Our Ref: BE/127/12/A
Your Ref:

Town & Country Planning (Control of Advertisement) (England) Regulations 2007 (as amended)
Application for Consent to Display an Advertisement(s)

Development Various non-illuminated & internally illuminated signage

Location Former LEC Site Shripney Way Bognor Regis

CHQ.12.9691-PL16

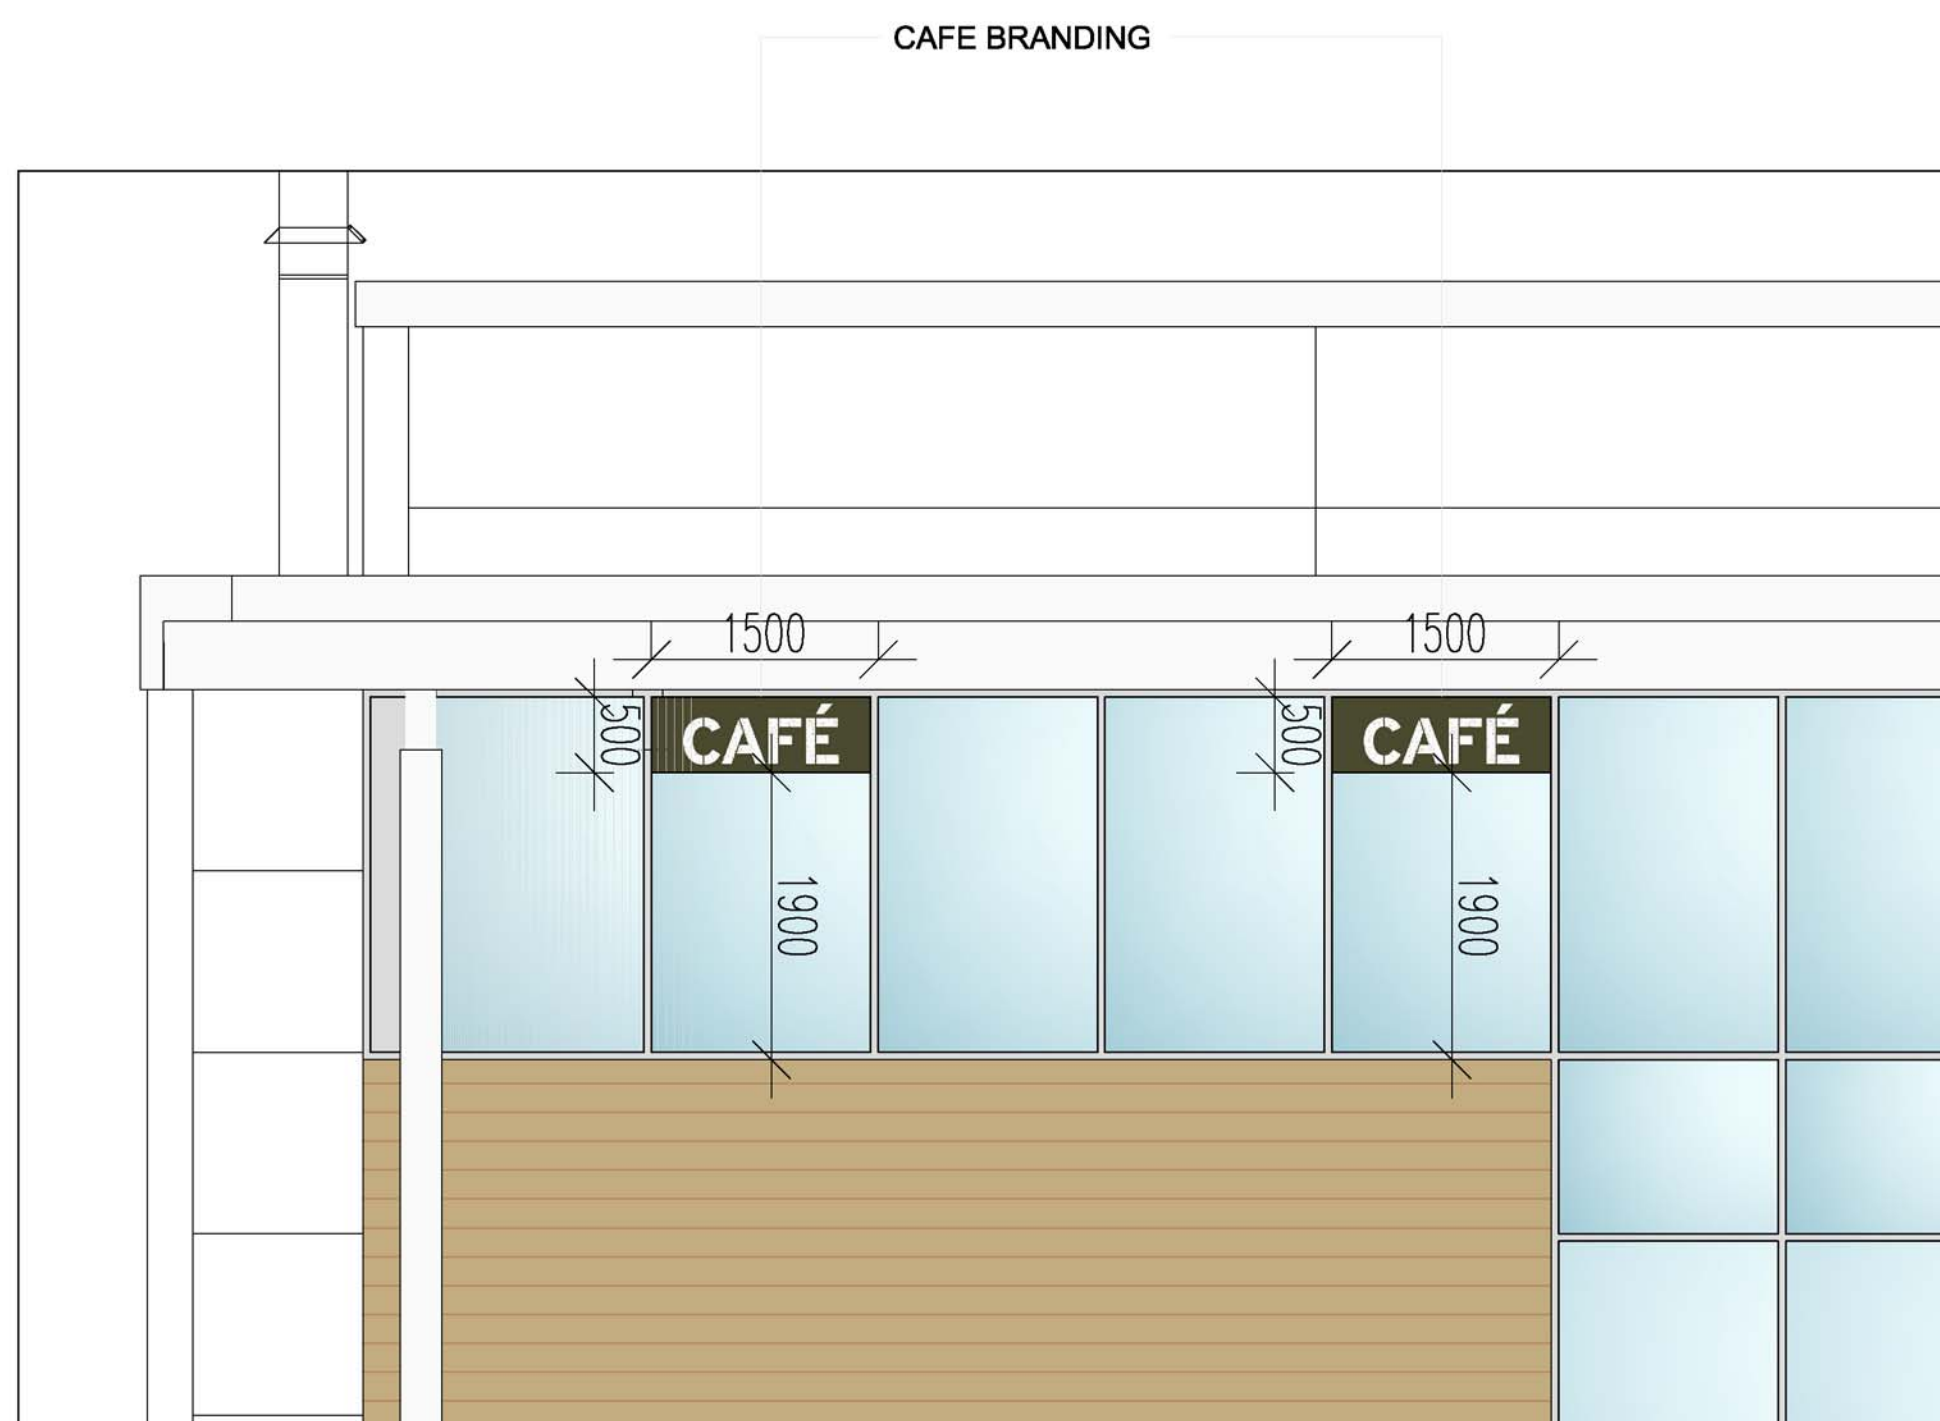
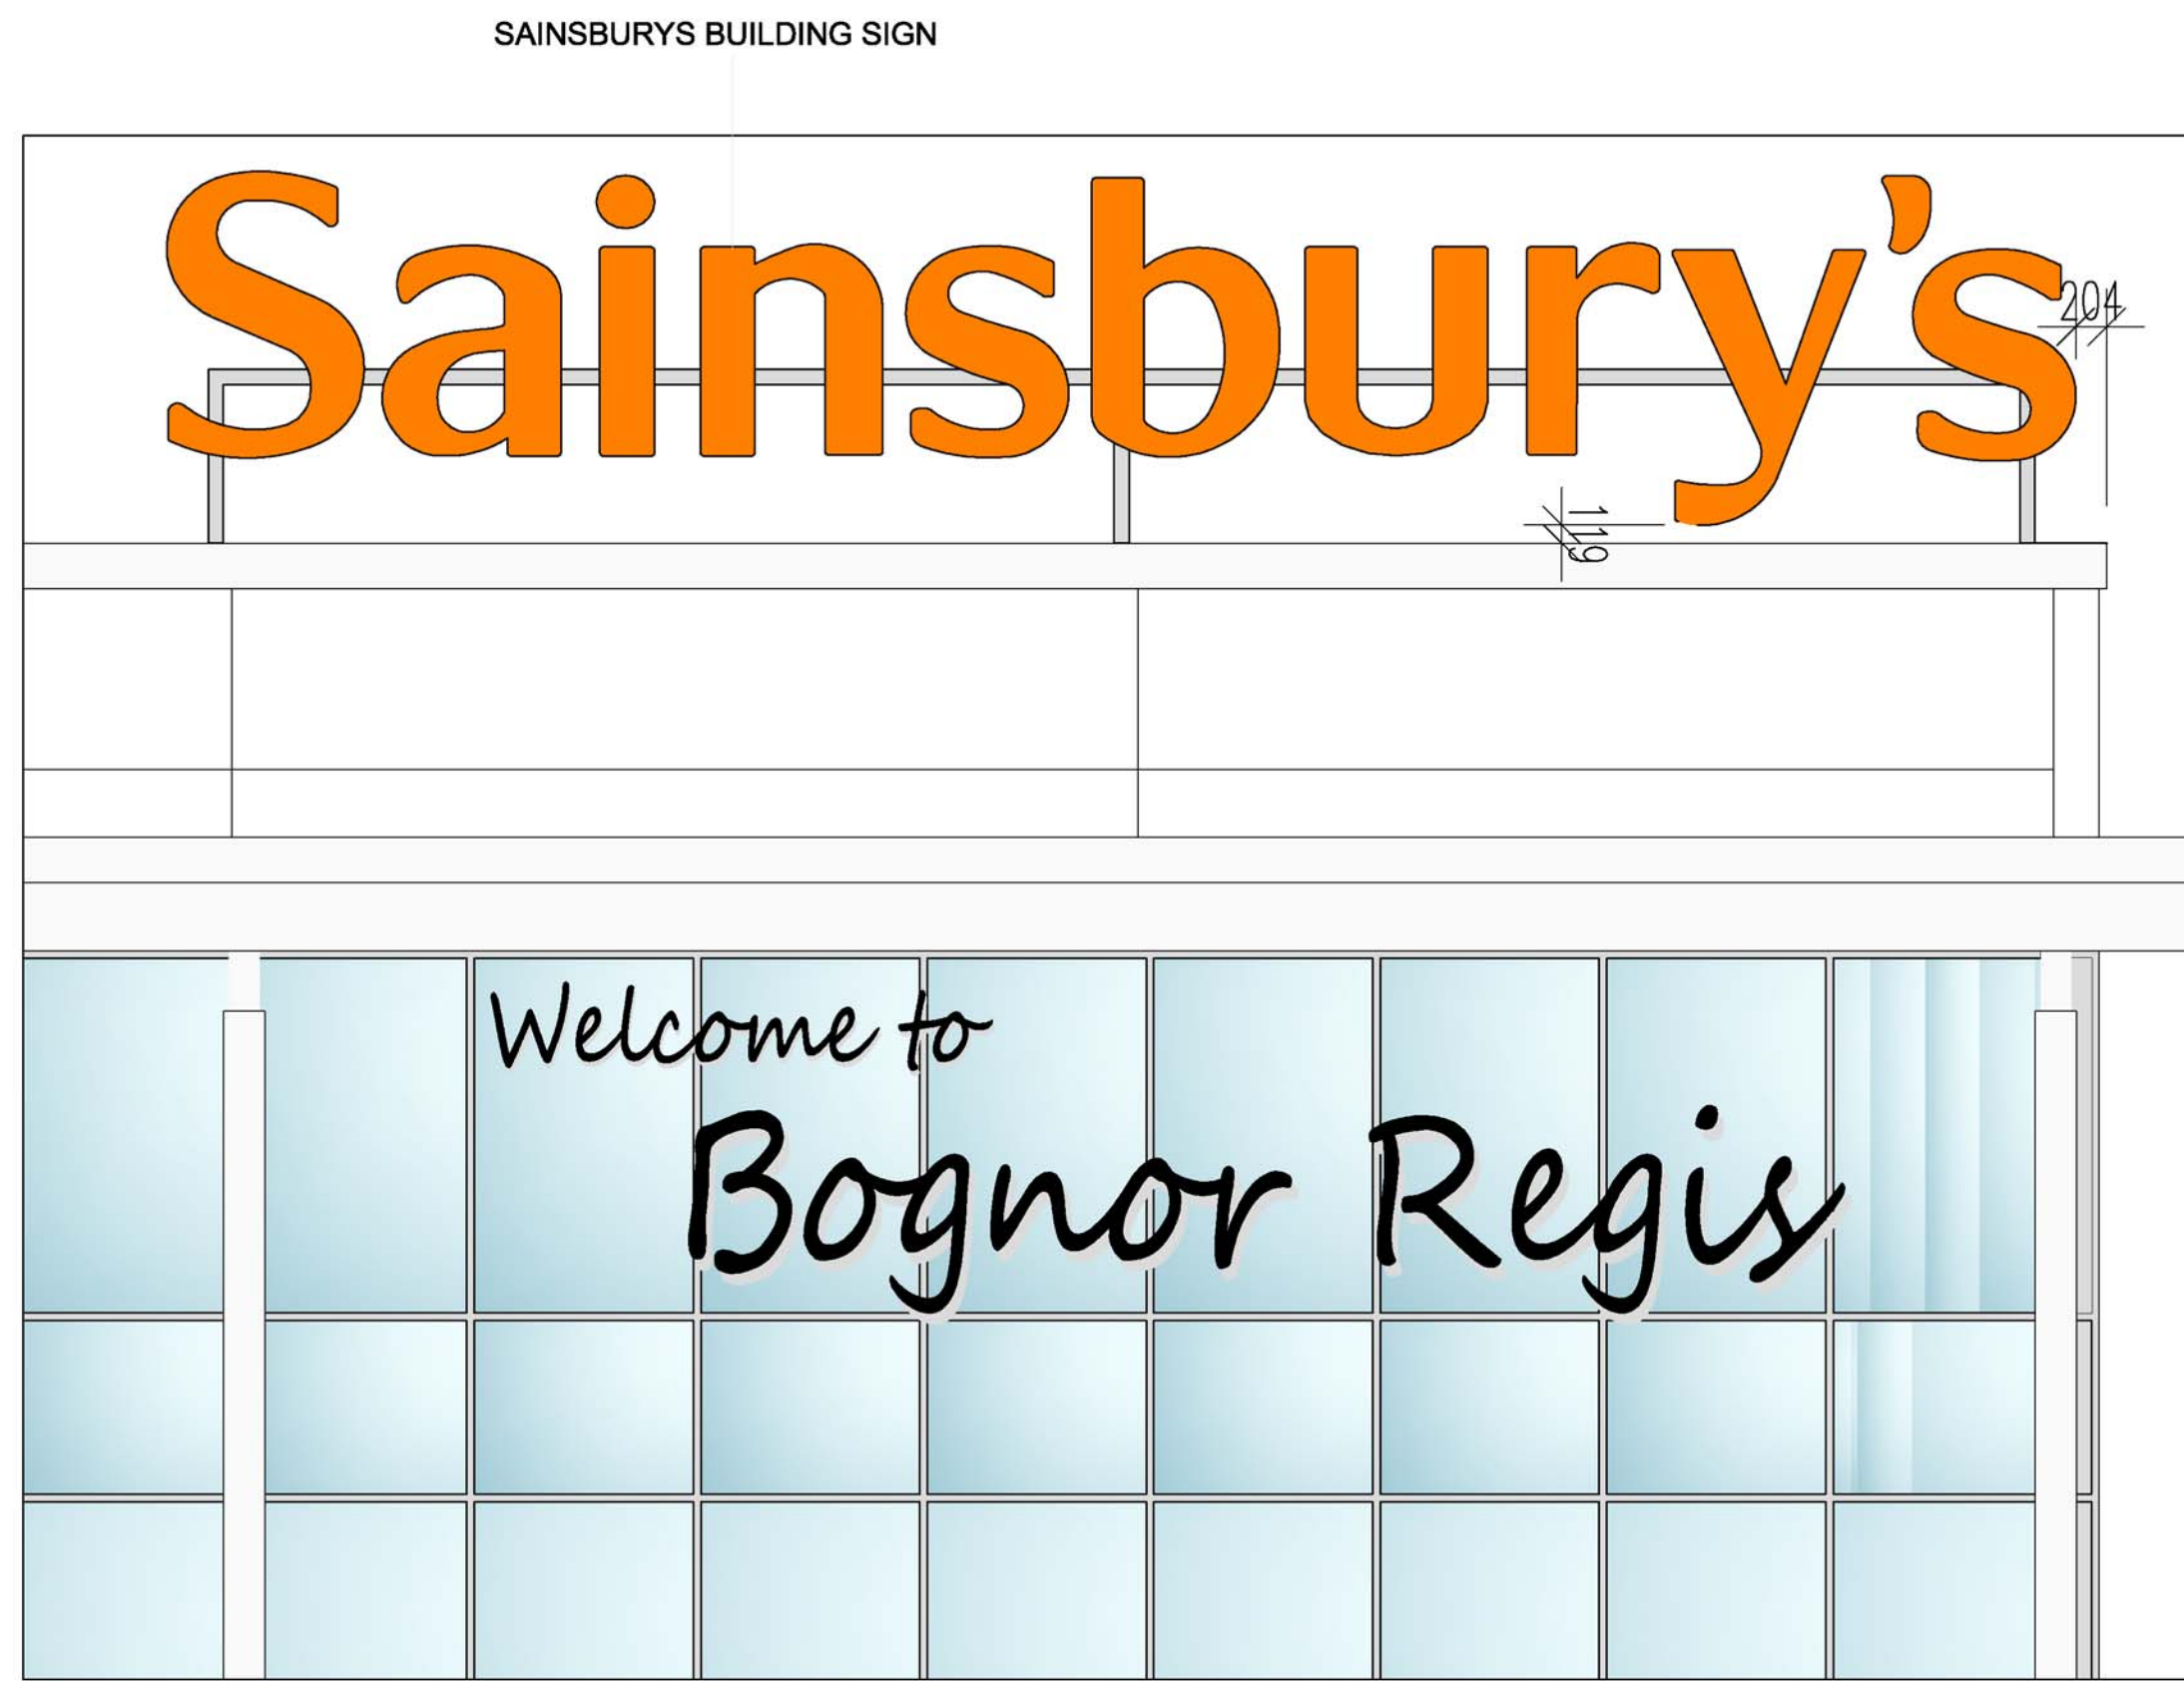
- The building signs (schedule) do not appear to be shown on the plans. Please amend.
- The schedule shows 1 'welcome to Bognor Regis' vinyl and 2 Sainsbury's wall vinyls. However the plans only seem to show 2 'welcome to Bognor Regis' vinyls and no Sainsbury's wall vinyls. Please amend.
- Other than the PFS totems, none of the petrol filling station signage on plan no. 2486/200 Rev A is shown on the schedule. Please amend.
